Registration Identification Number - 477
Application - M20 Junction 10a

**National Infrastructure Planning
Written Representation**

Prepared By: Ian Stevenson (Chair)
Date: 16th January 2017

Project Title		M20 JUNCTION 10A			
Drawing Title		RIGHTS OF WAY AND ACCESS PLANS			
Drawing Status		DCO SUBMISSION (TR010006)			
Scale		1:1250			
Original Size	Date	Designed	Drawn	Checked	Authorised
A1	JULY 16	RD	RD	FT	HNK
Drawing Number		HA514442-MMGLV-GEN-SMW-DE-Z-2403			
Revision		B

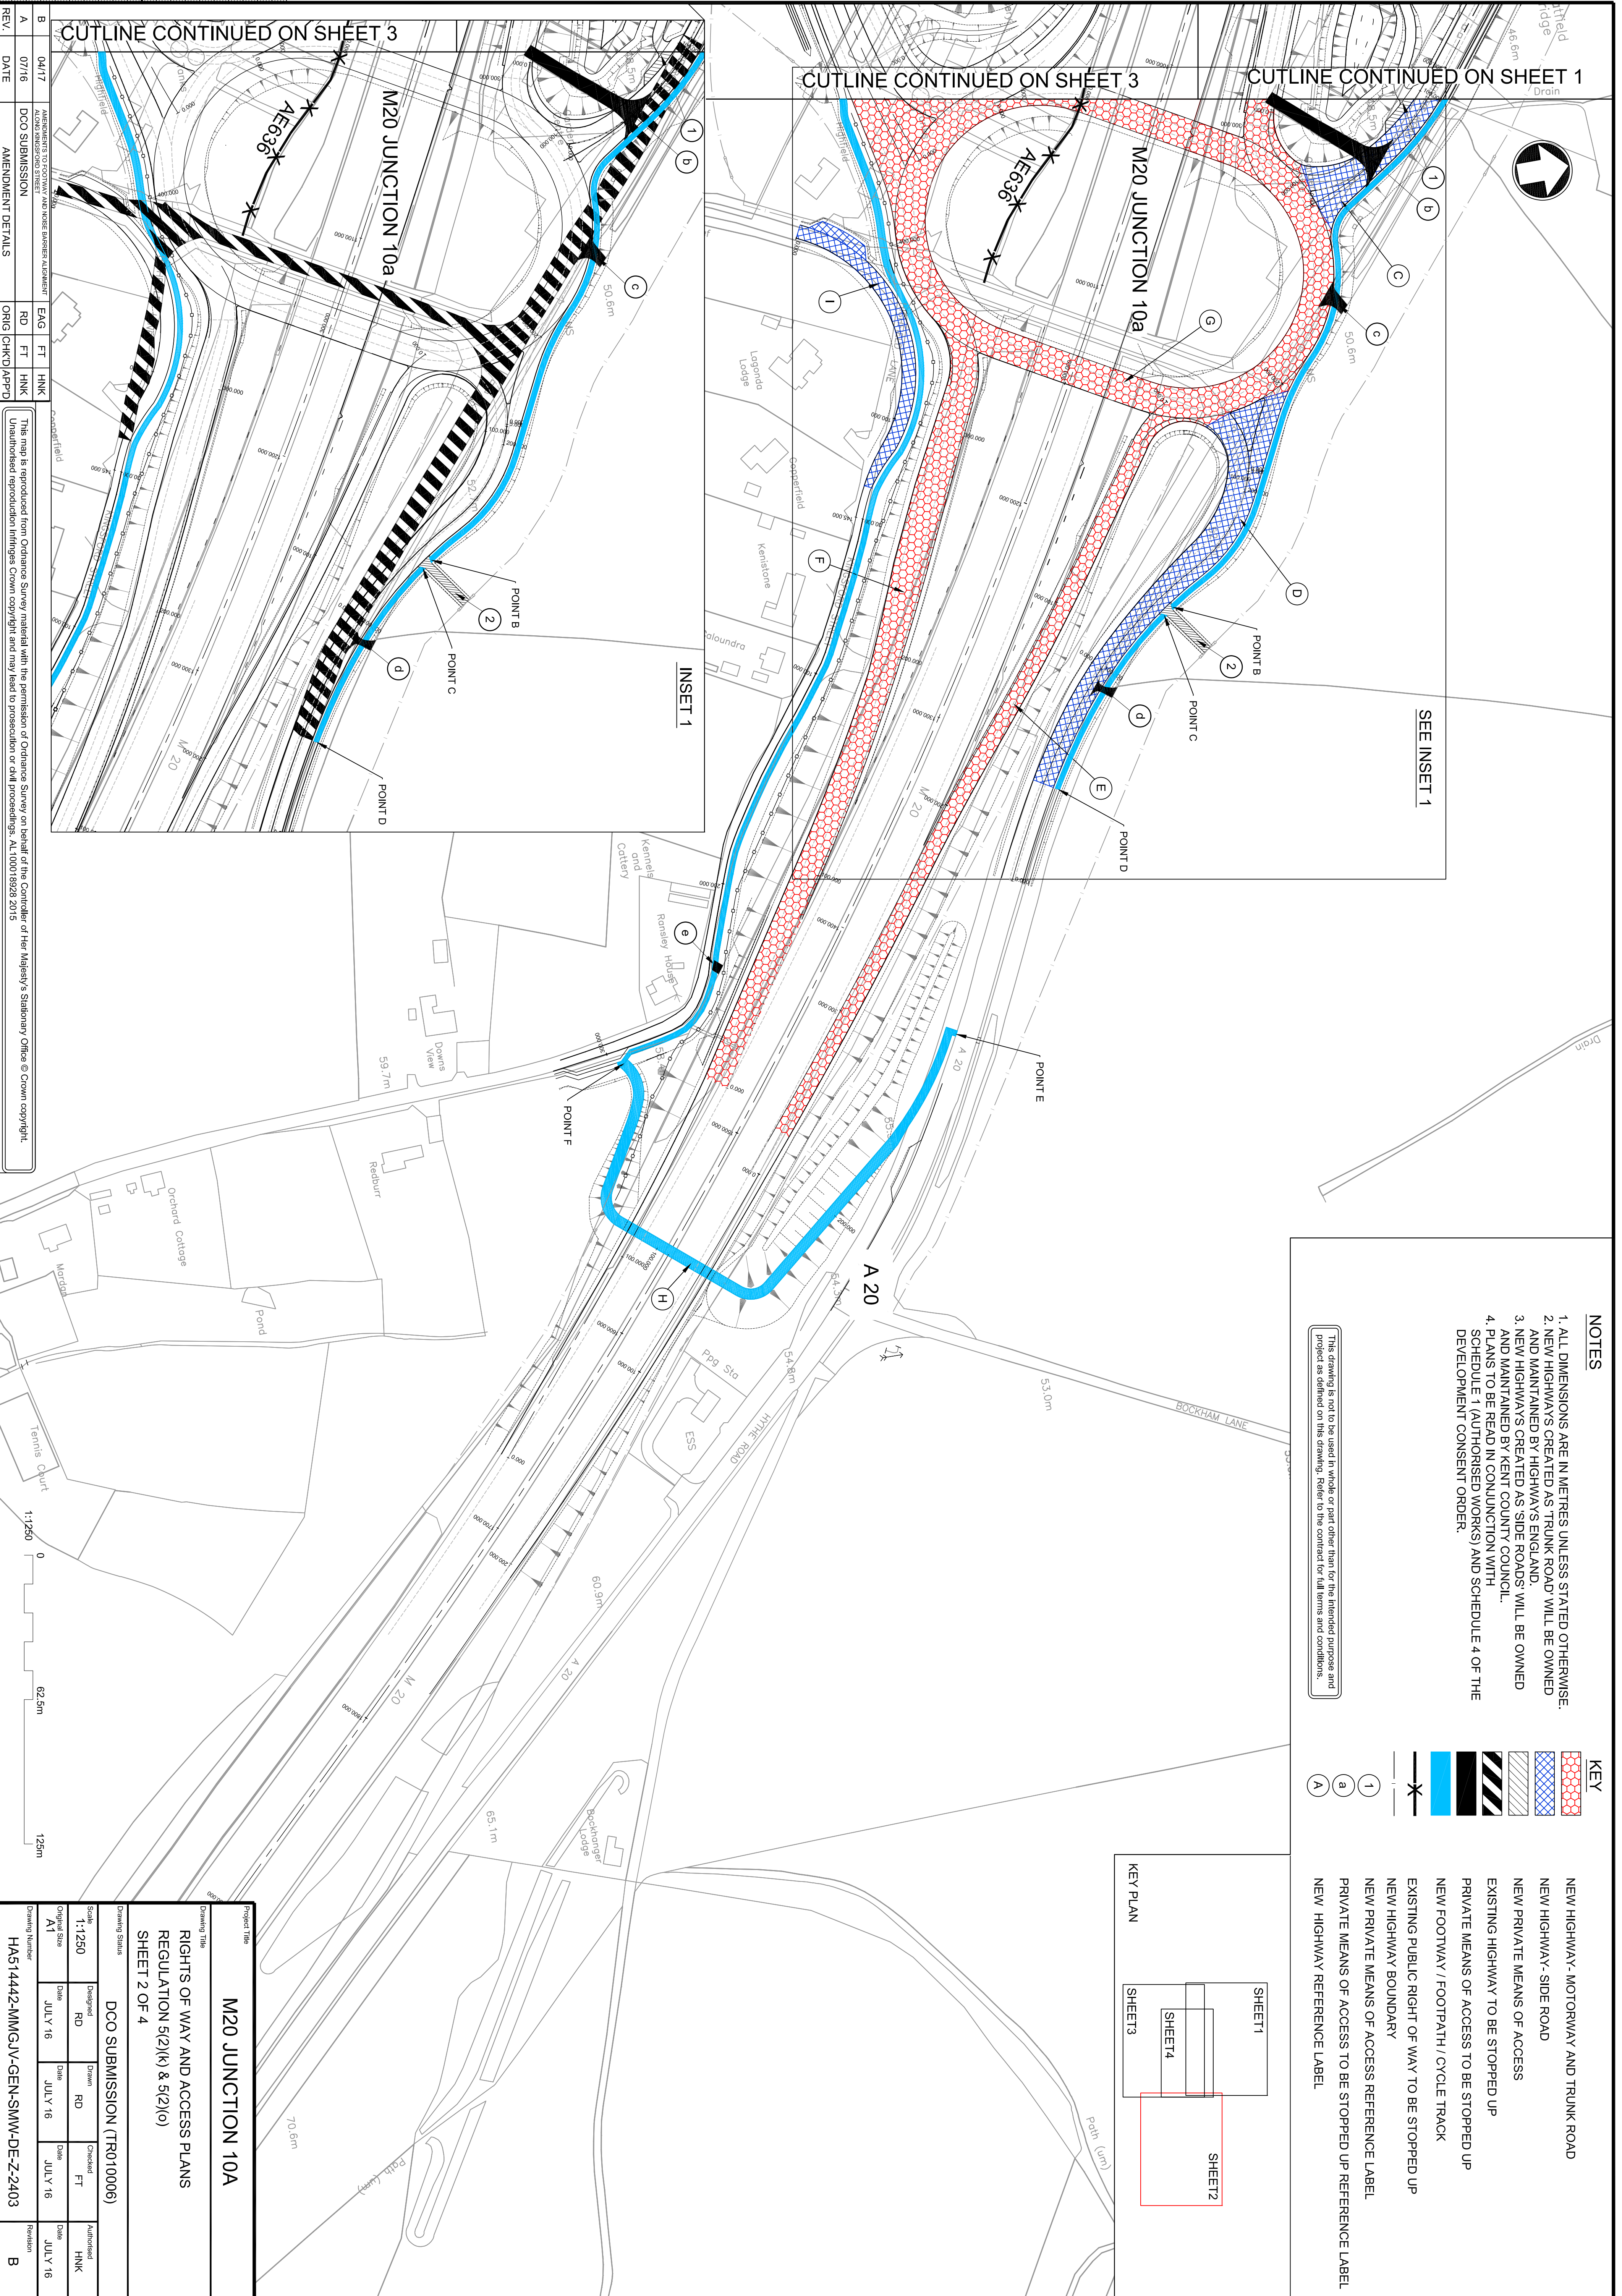
In view of this, talks are ongoing between HE Area 4, KCC, ABC, residents and business owners to try to broker a solution. We are therefore surprised that, rather than leave the Barrey Road/A2070 junction issue to this group, HE intend to modify the junction under the J10a scheme:

“The existing A2070 /Barrey Road junction would modified with a new a new left turn lane introduced from the A2070 into Barrey Road.”

(Ref Section 2.3.6 of document Volume 6.1 Chapter 2-The Proposed Scheme (TR010006-000175-M20_J10a_6.1_ES_Chapter_2.pdf) and as shown on drawings in document 2.6 General Arrangement Plans (TR010006-000155-M20_J10a_2.6_General_Arrangement_Plan.pdf))

The J10a scheme should either incorporate a proper solution to the junction, in line with their cost/benefit analysis, or omit the left turn lane and leave it wholly to the new multi-party group, especially as their proposed modifications could conflict with the solution currently being worked out.
